Please ask for: Mrs D Johnson
Email: daun.johnson@arun.gov.uk
Telephone: 01903 737762
Our Ref: BR/65/22/L
Your Ref:
Date: 28th March 2022

Listed Building Consent for Alterations, Extension or Demolition of a Listed Building

Development: Listed building consent for the change of use of 5 No self-contained flats for adults with learning difficulties to 5 No self-contained flats and formation of 5 No further flats from HMO rooms, garage and office, repairs and decoration of external surfaces, minor alterations to elevation facing Sadler Street, change one window facing rear courtyard to French doors & apply obscure film to 2 windows in courtyard area.

Location: Salisbury House The Steyne Bognor Regis PO21 1TX

GROUND FLOOR PLAN

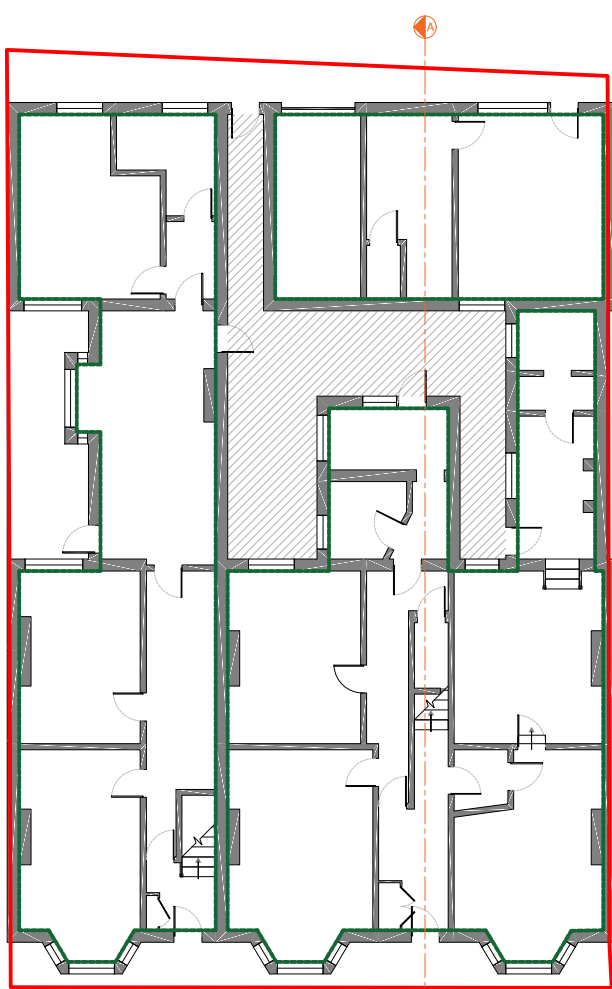
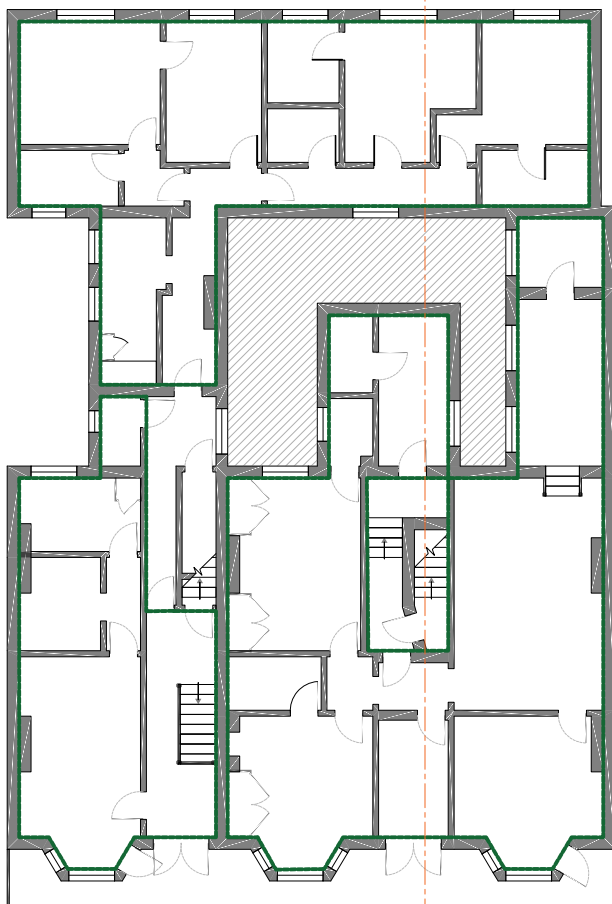
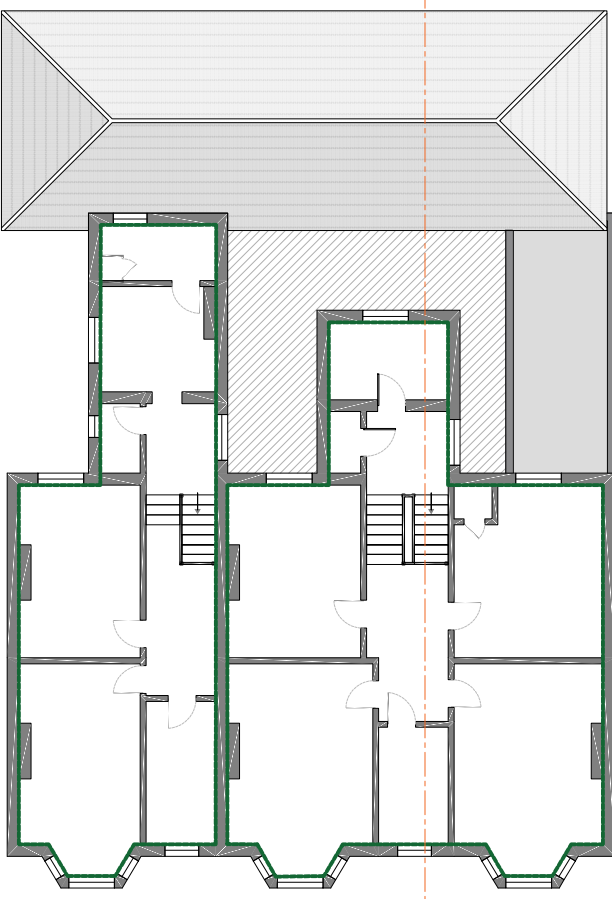
In the description of the proposed works 'change of use of 5 self contained flats with learning difficulties to 5 self contained flats', however, the existing floor plan shows no self contained flats. Please clarify.
